Our Ref: A/165/19/DOC

Approval of details reserved by condition imposed under ref A/74/18/OUT relating to Condition Nos 4 - acoustic, 5 - external lighting, 7 - contamination, 12 - hedgerows, 14 - surface water drainage, 15 - discharge of flows, 16 - SuDs and 18 - watercourse or culvert.

The Laurels Dappers Lane Angmering BN16 4EN

Arun District Council have decided to **REFUSE details reserved by condition for the following reasons:**

**Project:** Oceanview Developments  
**The Laurels**  
Dappers Lane  
Angmering  
**Title:** Proposed Drainage Strategy Plan

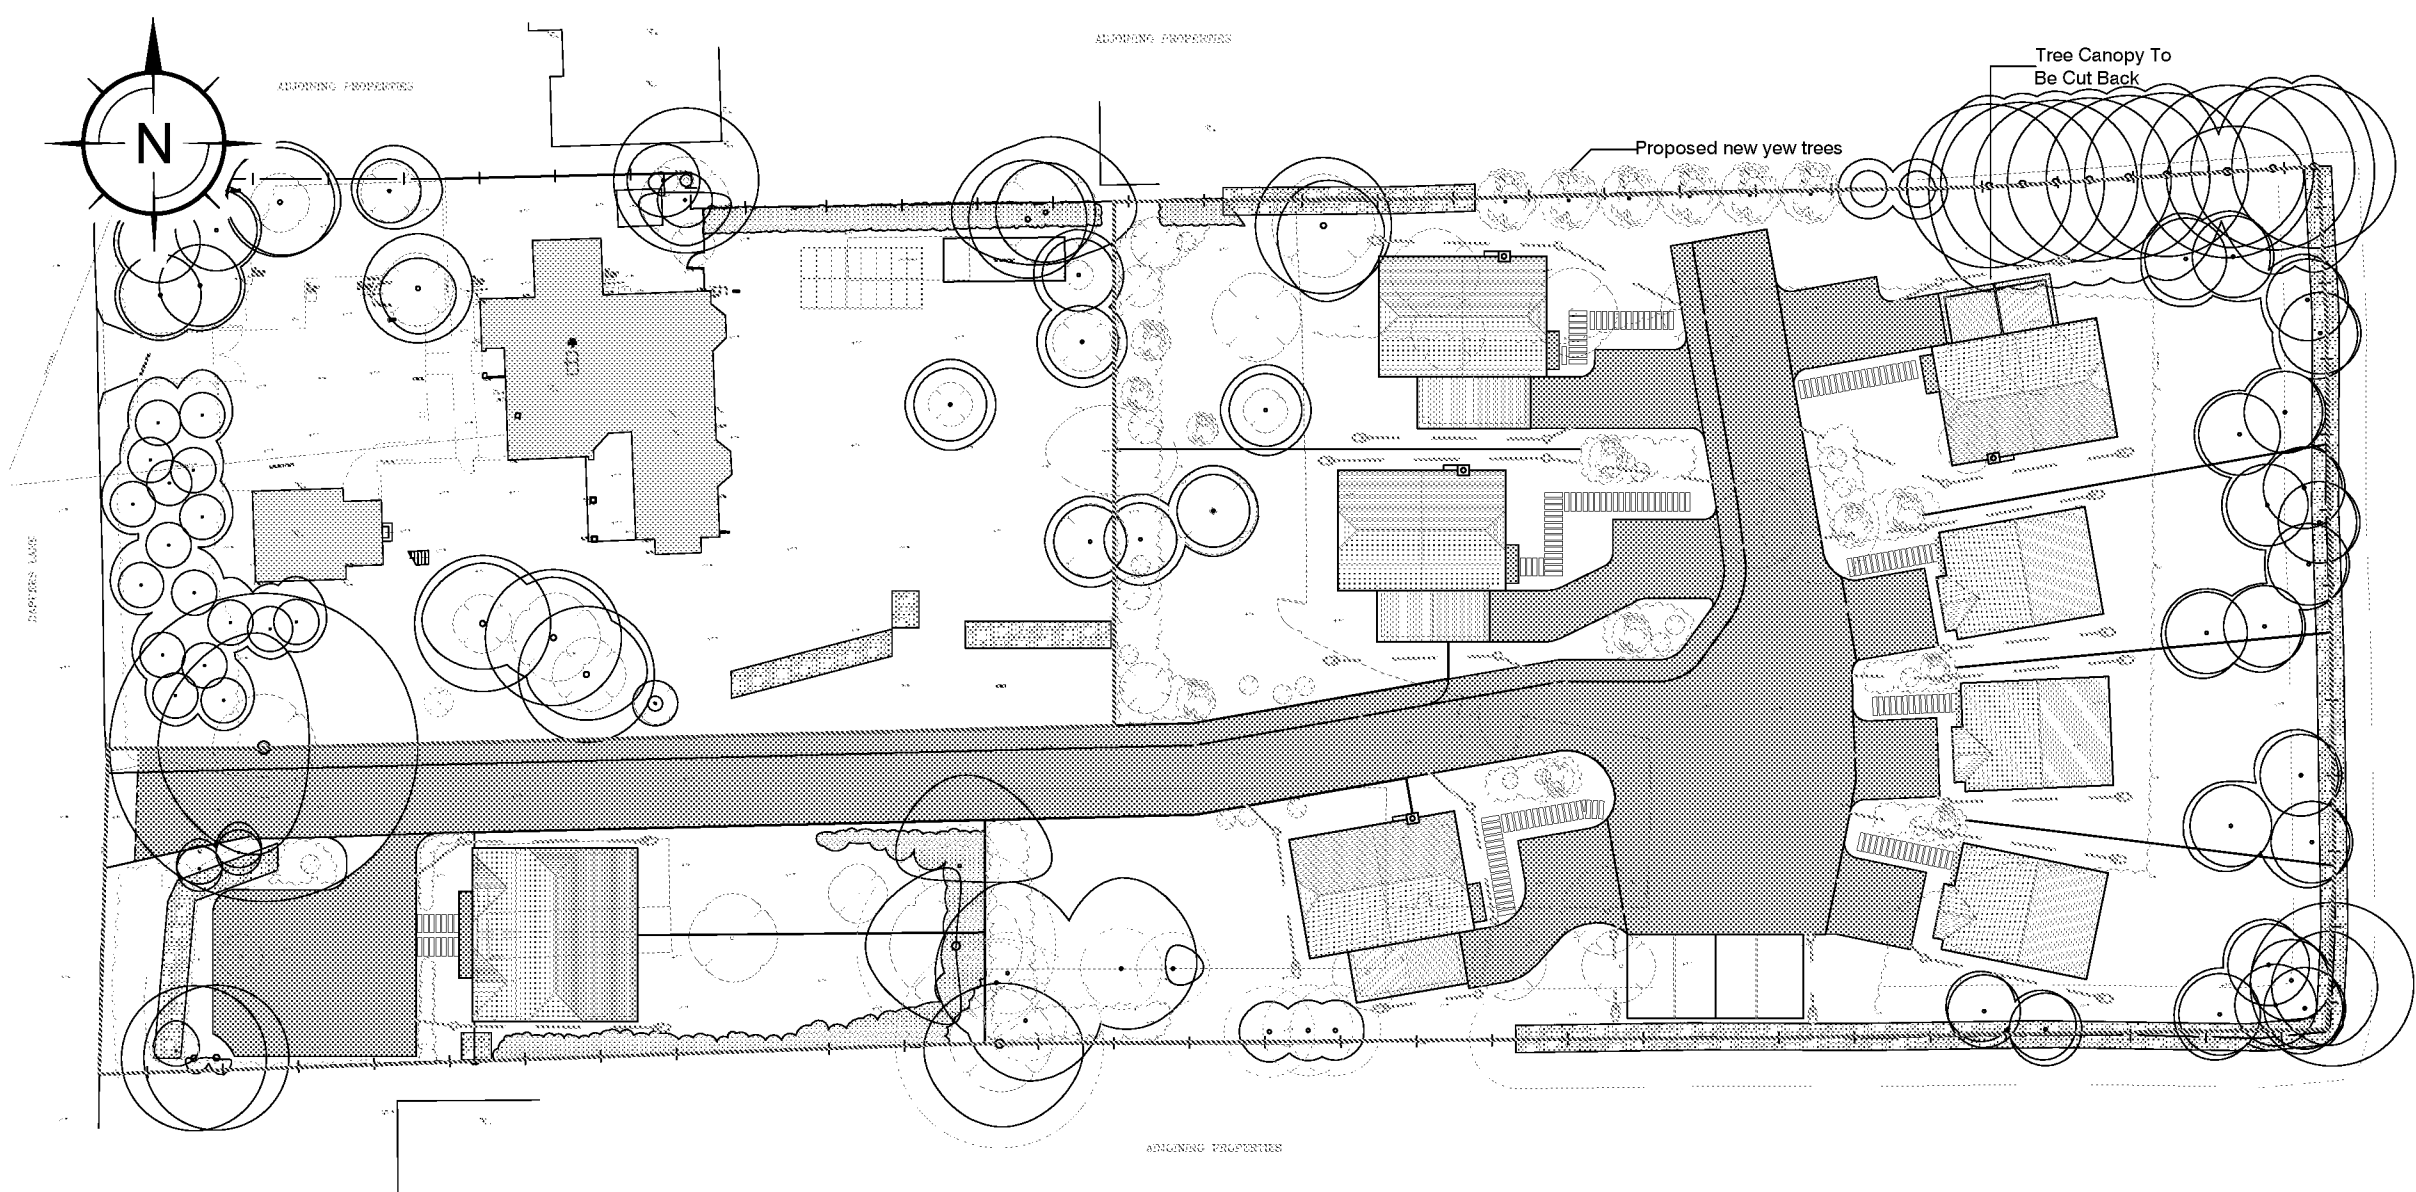
The applicant appears unaware that a culverted watercourse that runs along the western boundary. The following details should be provided so further comments can be made;

- a) A plan showing its location.
- b) Position/photos of any existing manholes on the culvert adjacent the site including immediately upstream/downstream.

- c) Manhole/culvert invert levels/cover levels.
 - d) Pipe diameter/material.
 - e) An internal CCTV survey inspection.
 - f) Proposed finished levels above the culvert.

- g) No new tree planting to be undertaken in the vicinity of the culvert. This needs to be made clear on the drawings.
2. Provide a fully detailed foul drainage proposals plan.

- Undertaking testing within boreholes does not meet this criteria. It is noted that TP02 failed to infiltrate sufficiently, so more detailed investigations/testing will be required in that area. It is strongly recommended that the applicant agrees the location/depth of the test holes, before actioning. Until such time that items 3 and 4 have been resolved, it is not possible to comment in any great detail on the proposals. Some suggested requirements below need to be considered;

5. Whilst permeable paving is likely to be the way forward, due to the lie of the land, the design will need to ensure that water does not all run to the lower end of the site via the sub base, so the paving will need to be compartmented to ensure that water is contained within each structure. This arrangement will need to be fully detailed in terms of construction details and proposed finished/bed levels and supported by storage/infiltration calculations for each section. Please note that on the example calculation sheets, a porosity value of 0.95 has been used. Whilst this is acceptable for permavoid blocks, granular stone should be 30%, so the calculations will need to reflect the construction of each specific section of permeable paving. Where stone is to be used, this is to be type 3 material (of specified grading/no fines) wrapped in a permeable membrane.

Figure 1 Site Plan
Exploratory Hole Notes
Exploratory Hole Records
Summary of Trial Pit Falling Head Soakage Test Results
Summary of Borehole Falling Head Soakage Test Results

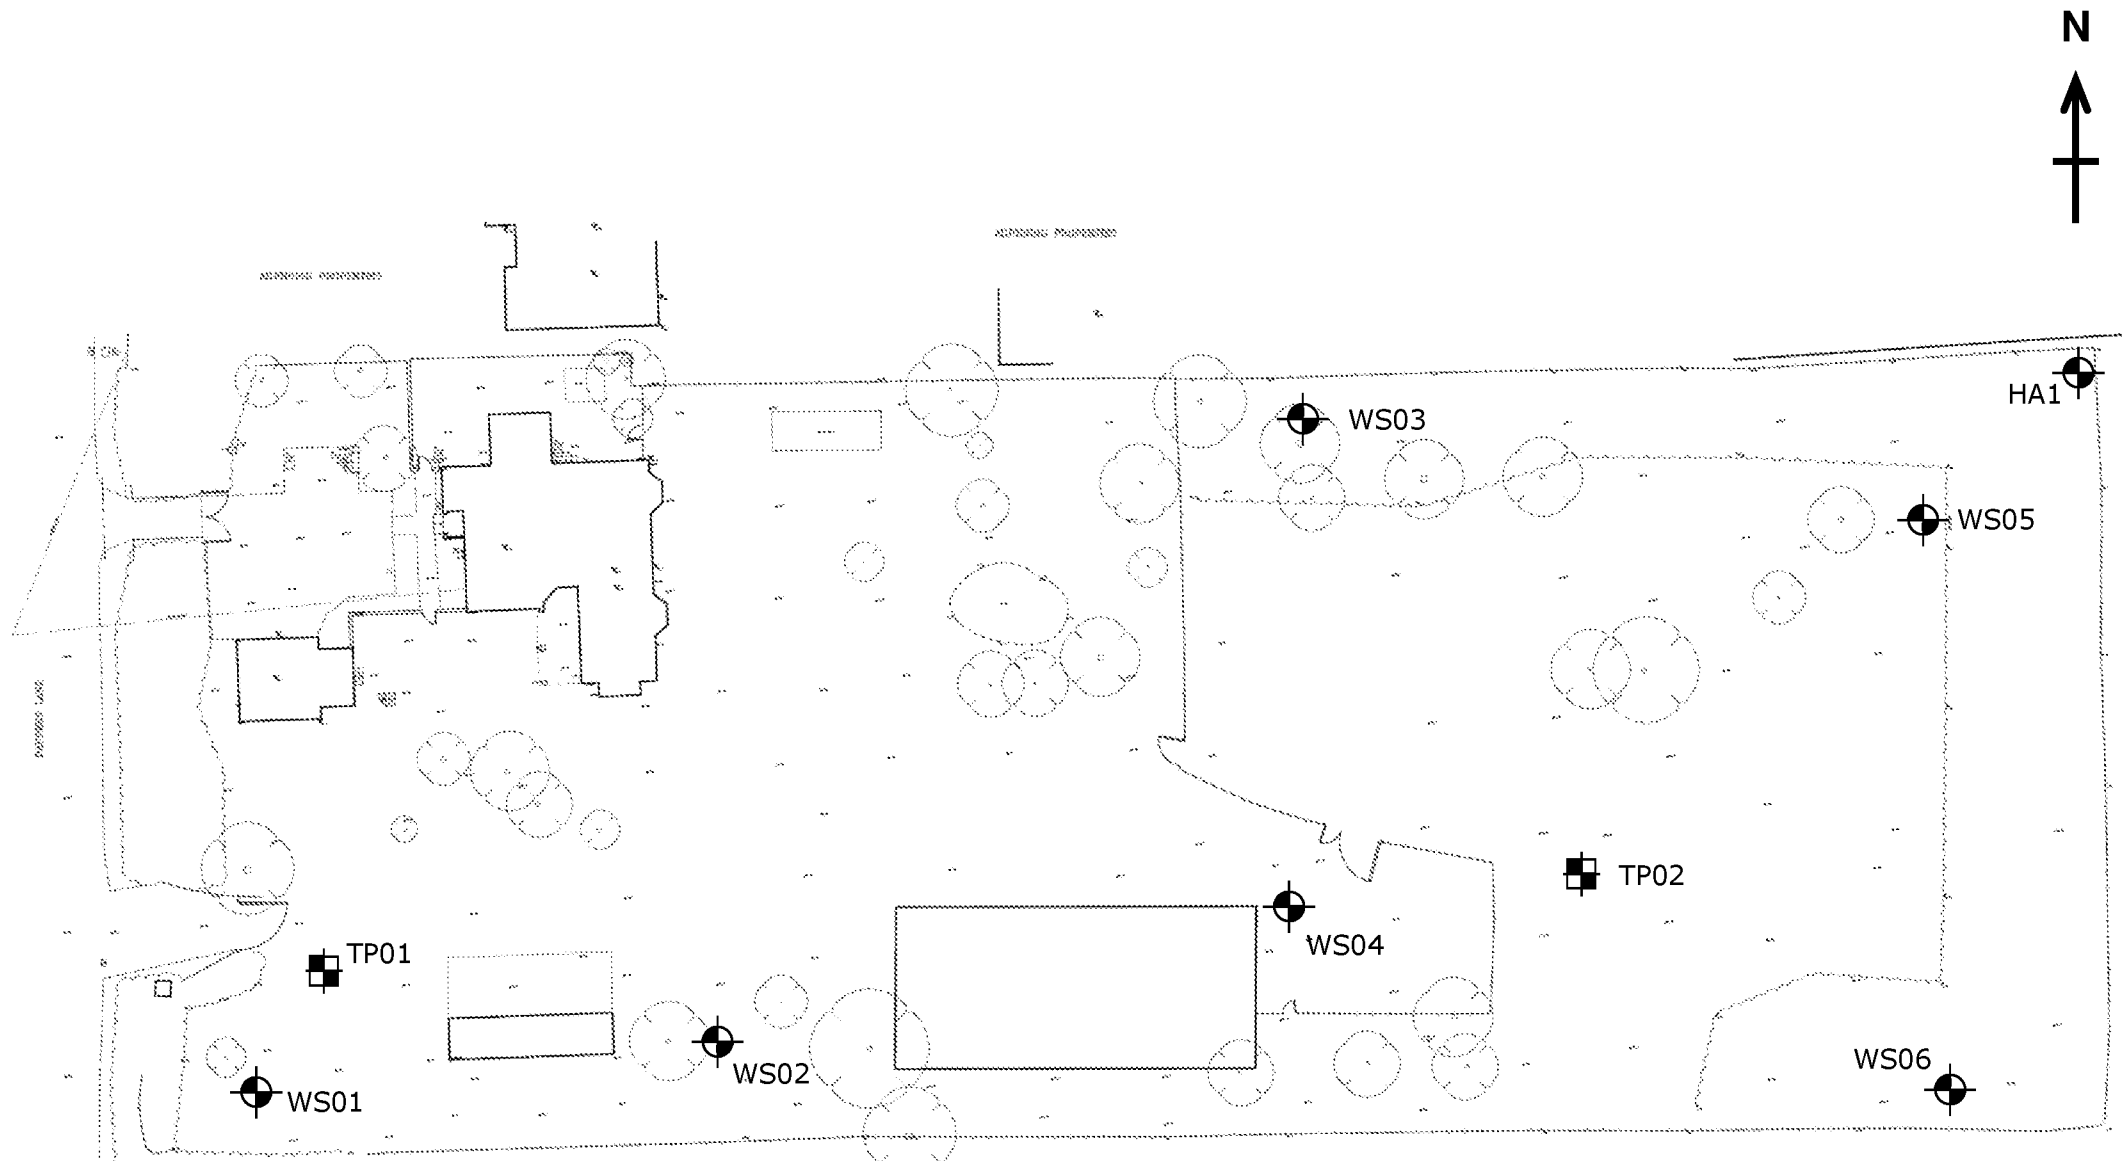
3. In terms of groundwater monitoring, there appears to be a lack of data for a site of this size ie. WS04 was the only borehole monitored. I would like to see further winter monitoring carried out in WS01 which is the lower section of the site. I suggest this is implemented immediately and monitored accordingly. The extent of monitoring will need to be agreed.

4. The percolation testing was carried out in October 2018 which does not fulfil our requirements in terms of winter testing. Therefore, further infiltration testing will be required, in say January, at the location and depth of the proposed infiltration structures. These must be in strict accordance with BRE365.
